35810/APP/2026/735 - Tavistock Works - Design Comments

1. Summary:

Figure 2.1: Proposed Site Plan Ground Level

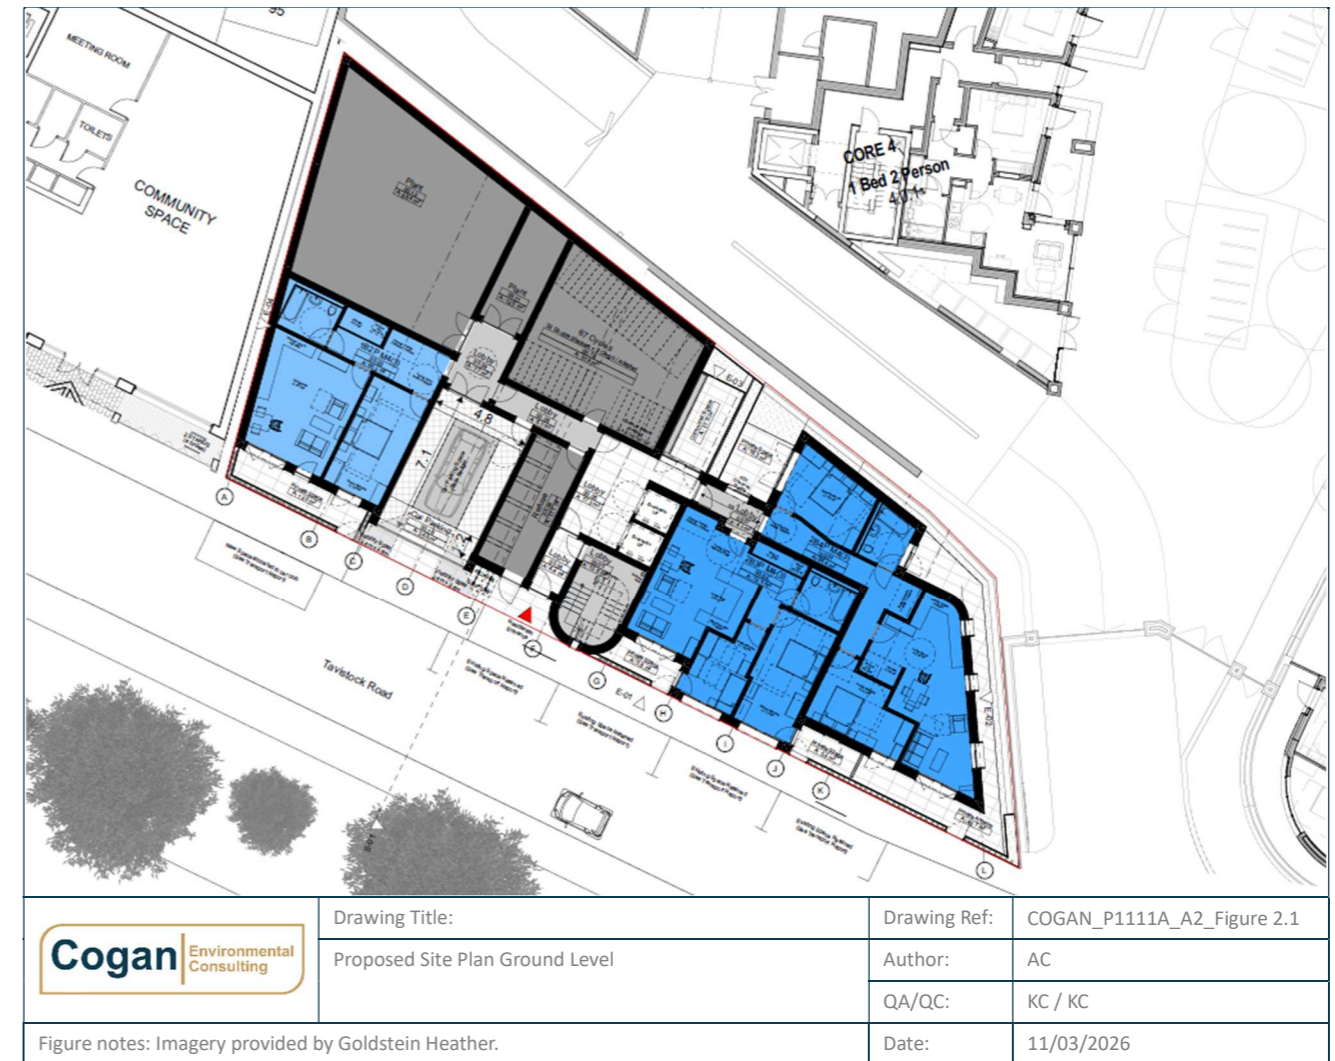
Currently the entrance is very poorly articulated - difficult to spot from the street and doesn't look like a main entrance to a fairly considerable apartments block. While we support use of a material that distinguishes the entrance and couples it visually with the circulation core, more design work is needed to make the entrance more legible and visually celebrated / prominent.

There is some scope to make the entrance project out more to make it more prominent. Please note, entrances for apartment blocks typically require canopies projecting 1200 mm (Part M Buildings Regs) - we suggest this is incorporated as part of the redesign to make the entrance clear, legible and attractive. Poorly designed projecting canopies will not be considered acceptable (e.g. stuck-on glazed canopies or other similar).

- location of mail boxes
- space for deliveries

Typically it is advisable that refuse stores are only accessed from the outside to prevent security breaches via the secondary door which undermines the lobby two-point-security arrangement.

The corner unit has not been designed well and can be optimised even within the footprint currently outlined for it.

The accessibility transit area has moved into the unit and is less convenient than before (at entry).

The unit loses too much space into corridors due to its layout, location of living room and bedrooms - if one moves the living room at the very end (instead of a bedroom at the end as currently), this can help shorten the corridor and regain some area back / optimise floor area use. Ideally the living room should face Tavistock Road (the more primary street) and the more private spaces (i.e. bedrooms) should be located away from that aspect - for privacy.

Access into the ground floor forecourt via a bathroom is not acceptable. Any front garden / forecourt should be accessed via the living room, or at the very worst via one of the bedrooms (although via bedroom is also substandard).

Locating bedrooms at ground floor with aspect directly onto a primary street (e.g. Tavistock Road) without any buffer in between is broadly not something we should be supporting. If this can be optimised - would be beneficial.
